STAFF REPORT Brown Road Long Plat (LP-25-00003)

Requested Action: Brown Road Estates LLC submitted an application for a 9-lot plat (subdivision) of 1 parcel totaling 45.77 acres of land. The proposal includes 9 residential lots ranging in size from 5.0 acres to 5.76 acres. The subject property is currently zoned Agriculture 5 with a Rural Residential land use designation.

TOTAL ACREAGE: 45.77 ACRES  
NO. OF LOTS: 9  
ZONE: AG 5  
ASSESSOR'S NO. 618133

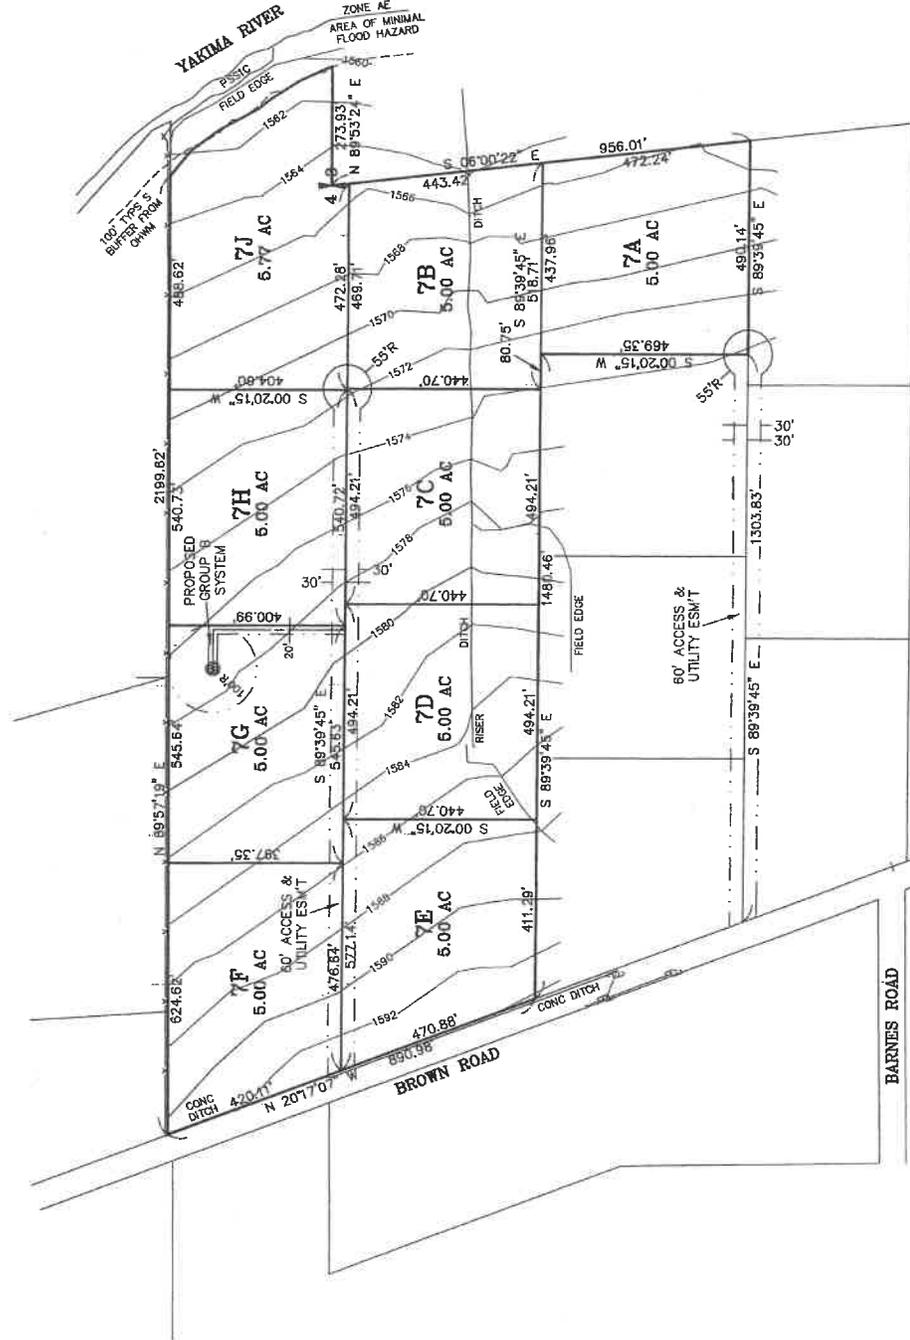
- 24) Survey legend, Engineer of Record, and Brown Road need to include width, ownership, and surfacing.
- 25) Record land descriptions need to be shown, matching subdivision guarantee of record.
- 26) Adjacent subdivisions need to be labeled, and easements shown shall include notation if they are existing or proposed.
- 27) Basis of bearing needs to be addressed.
- 28) The final plat shall meet the requirements of KCC 16.20.
